August 10, 1984

RE: REVISED GRADING & DRAINAGE PLAN FOR WAREHOUSE FOR LARRY VIGIL
(J-14 D-42) AT 210 CONSTITUTION N.W.

REF: WAREHOUSE FOR LARRY VIGIL (J14-D42)

DESIGNED BY S.D. E.D.	DRAINAGE & GRADING PLAN WAREHOUSE for LARRY VIGIL AND SONS CONSTRUCTION COMPANY
DRAWN BY C.M. S.D.	
CHECKED BY E.D.	
MAY 1984	
PREPARED BY RESOURCE TECHNOLOGY INC.

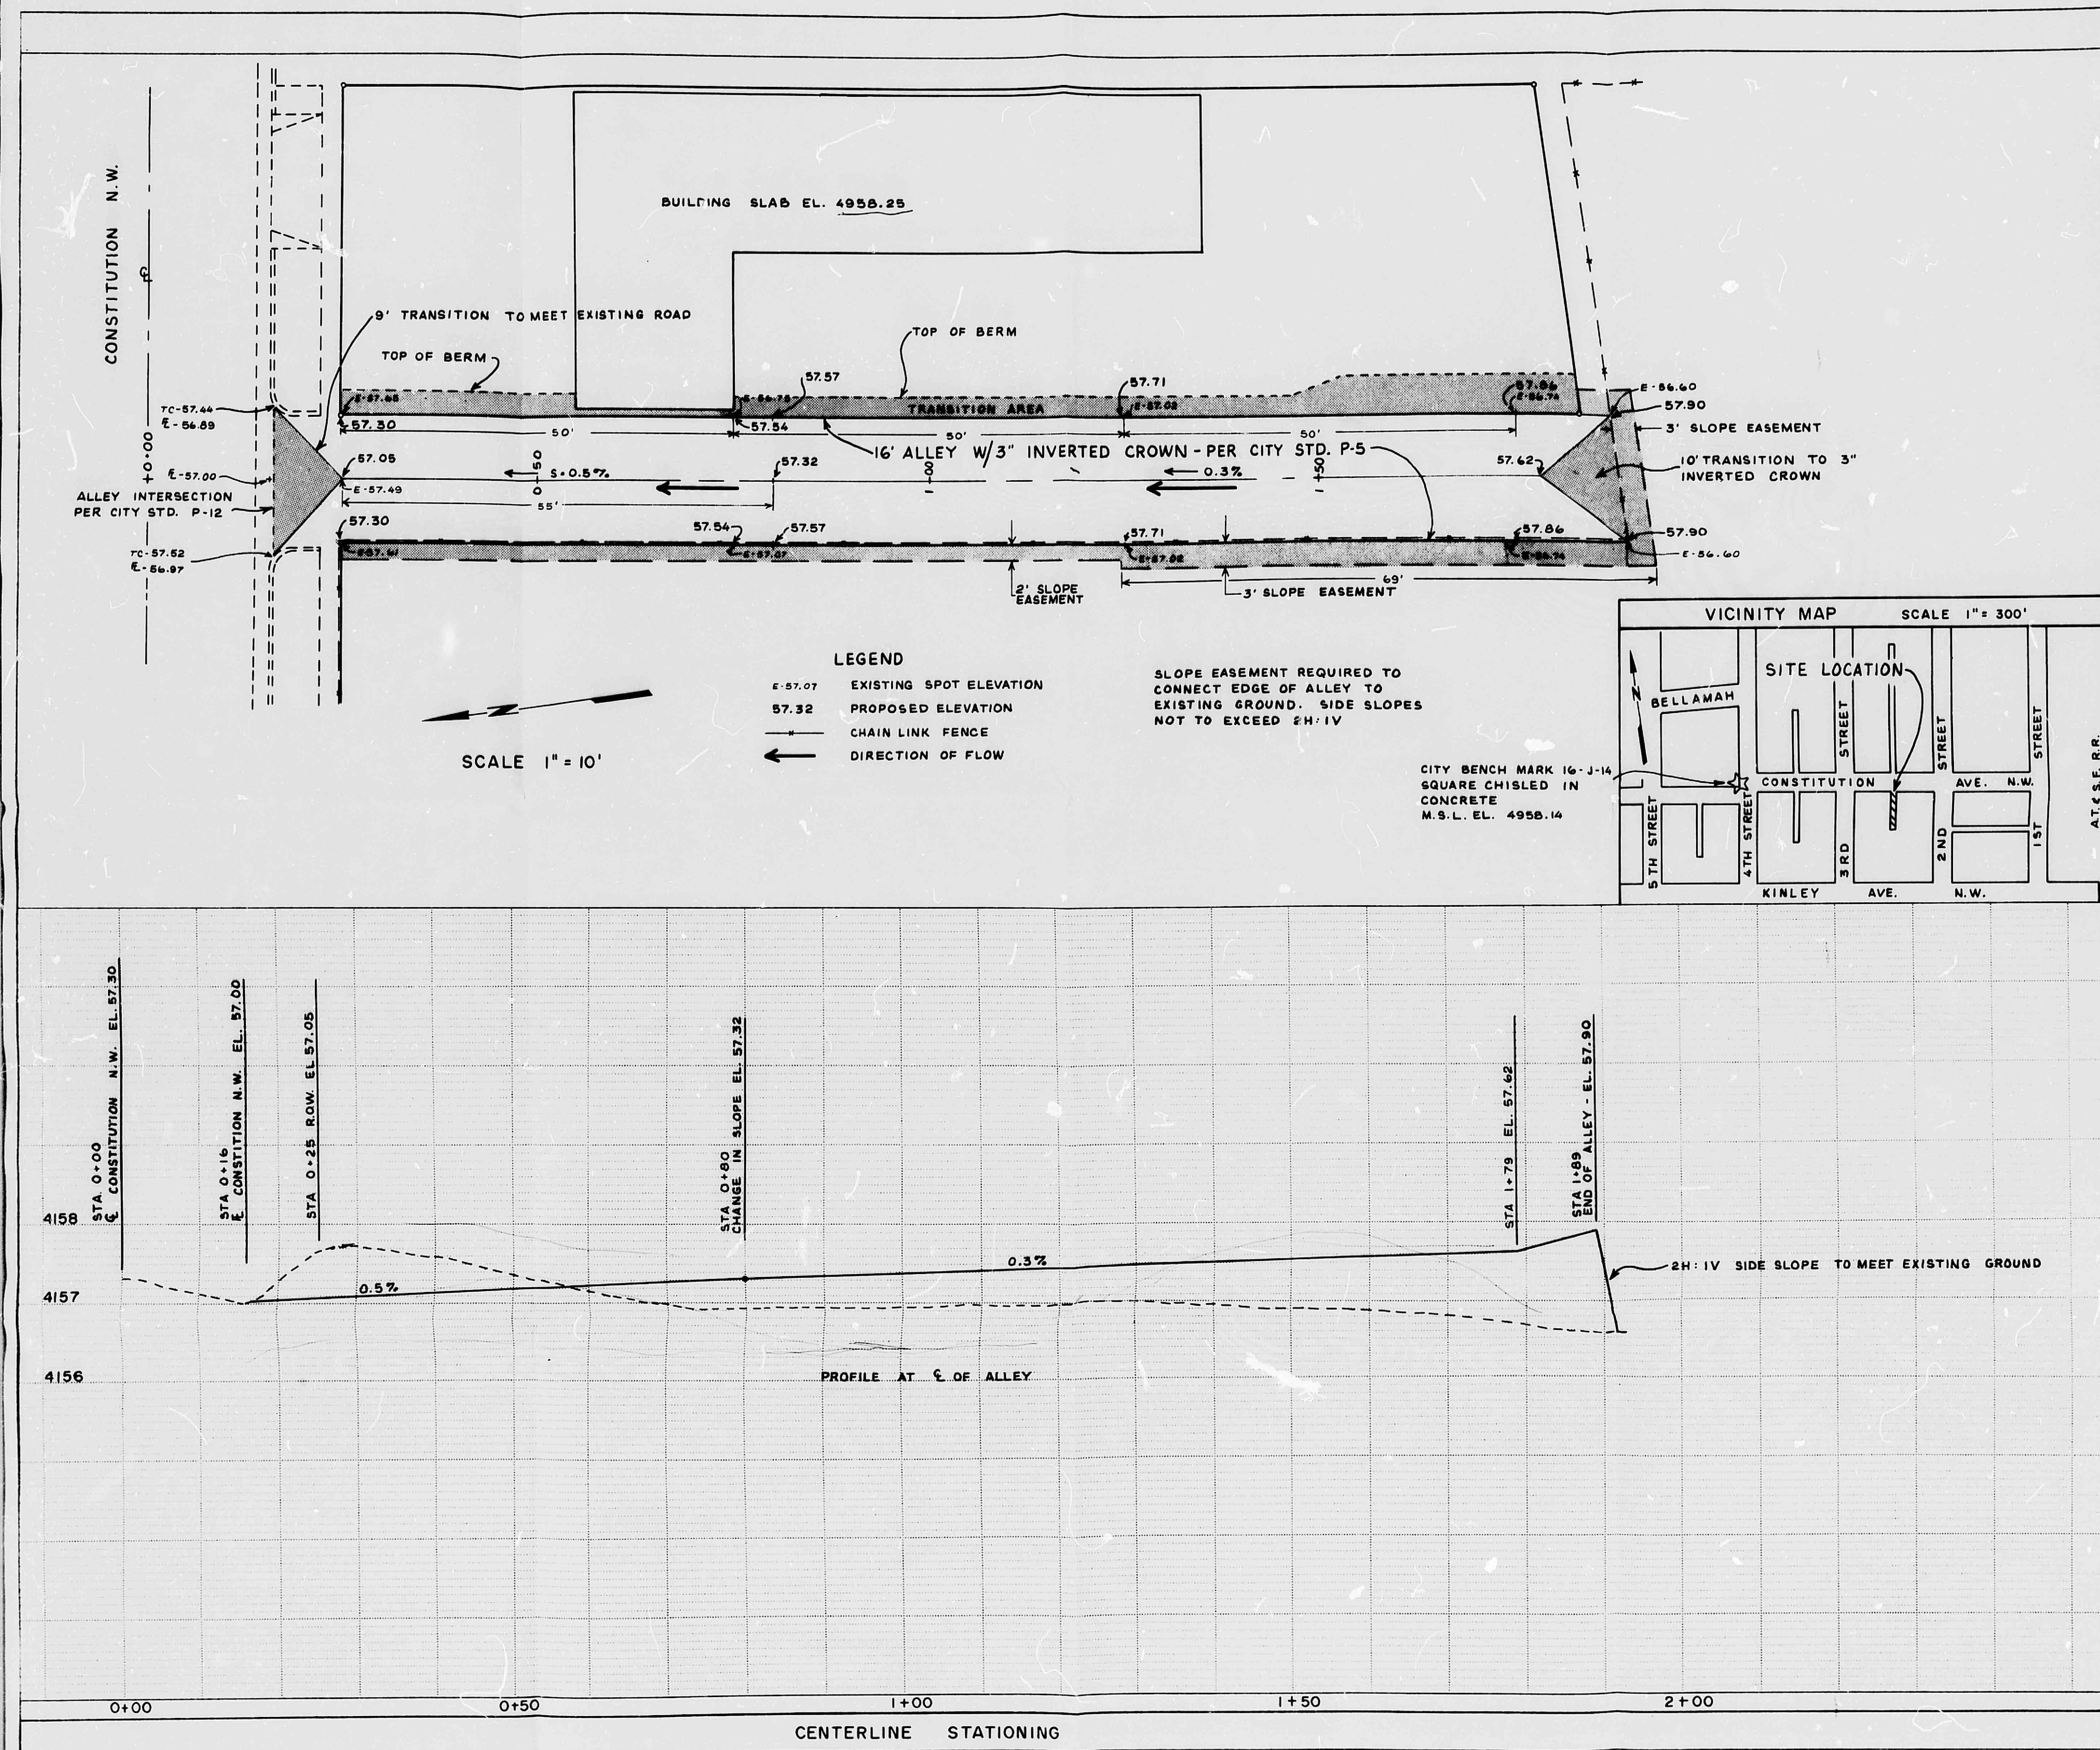
1. City approved alley grades will need to be incorporated with your design.
2. Private easements for the proposed drainage scheme across property lines will be required (an alternative to this easement would be to remove the common lot lines between the lots by replatting).

- ✓ 1. Information sheet designating resubmittal.
- ✓ 2. Professionals stamp with signature and resubmittal date.
- ✓ 3. Please include a typical section of the pond with all applicable dimensions.
- ✓ 4. Please outline 100 year water surface elevation on plan.
- ✓ 5. Please include a typical section showing construction details for submersible pump.
- ✓ 6. How do you propose to control any sediment problems associated with the function of the submersible pump?
- ✓ 7. Please include a typical section for the proposed swales.
- ✓ 8. Please designate which are existing spot elevations and which are proposed on your legend.
- ✓ 9. Please identify internal contributing drainage areas including roof areas, outlined on plan.

10. Approved alley grades when site abuts a dedicated unpaved alley are required.
- ✓ 11. Benchmark location, description and elevation of the Albuquerque control survey vertical datum used.

Based on recent development regarding the City approved alley grades adjacent to the subject site, the general agreement between this section and City Design section is that this requirement would be inappropriate. Since the alley does not extend beyond one-half the block and to provide for the standard grading by importing an excessive amount of fill, the requirement for City approved alley grades is hereby waived. It is, however, strongly recommended that your client entertain having this alley section vacated as a dedicated alley.

Consequently, the above referenced plan, dated June 14, 1984, is hereby approved.
